CITY OF ALBUQUERQUE

**Re: ABQ Health Partners Primary and Urgent Care Facility Parking,
9101 Montgomery Boulevard NE, Traffic Circulation Layout
Architect's Stamp dated 07-09-12 (F20-D023)**

Based upon the information provided in your submittal received 07-12-12, the above referenced plan cannot be approved for Building Permit until the following comments are addressed:

AS-101

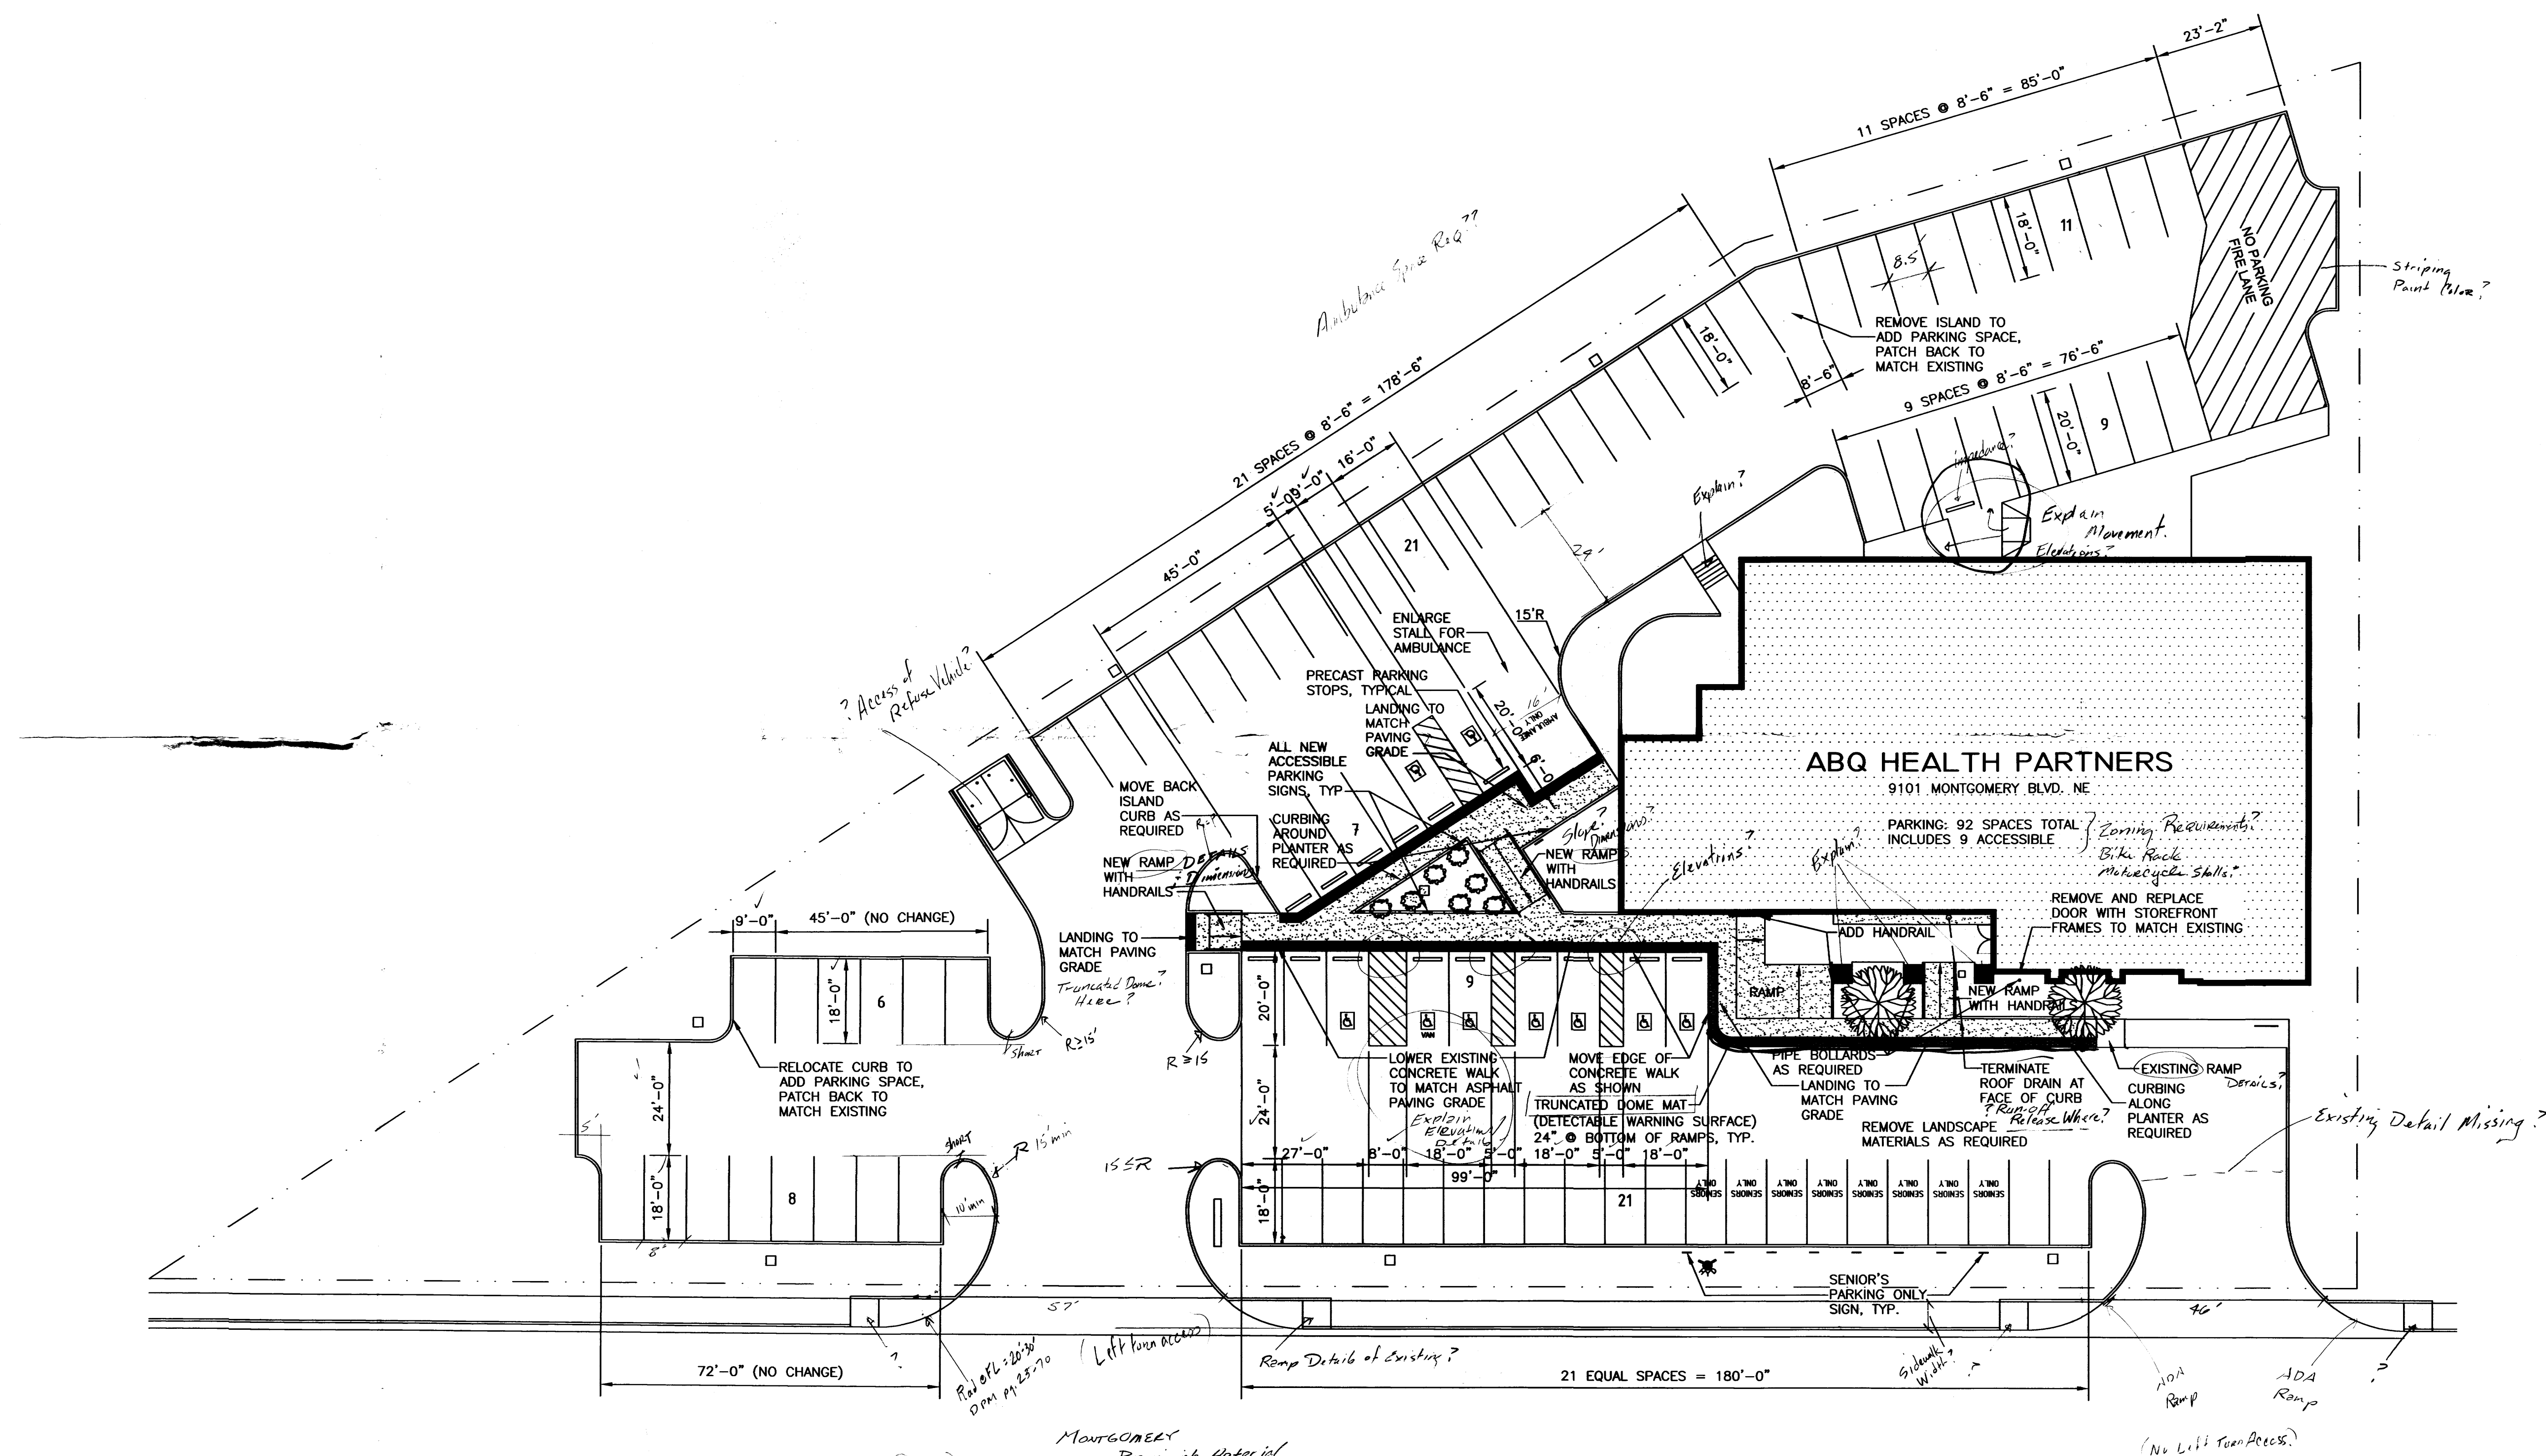
1. Please show a vicinity map.
2. Provide the legal description on the plan.
3. List the number of parking spaces required by the zoning code as well as the proposed number of parking spaces.
4. Provide a legend, defining all linetypes and hatching.
5. Per the *Development Process Manual*, Chapter 23, Section 7, Part A.6, "Curbing should be used to separate landscaping from parking areas and pedestrian ways." The proposed truncated dome mat south of the building does not appear to significantly separate the parking area from the pedestrian way.
6. It is unclear what is being proposed north of the building. Is this a drop off area?
7. The roof drain appears to be guiding drainage over the sidewalk; please clarify.
8. Define the maximum slope of the proposed ramps.
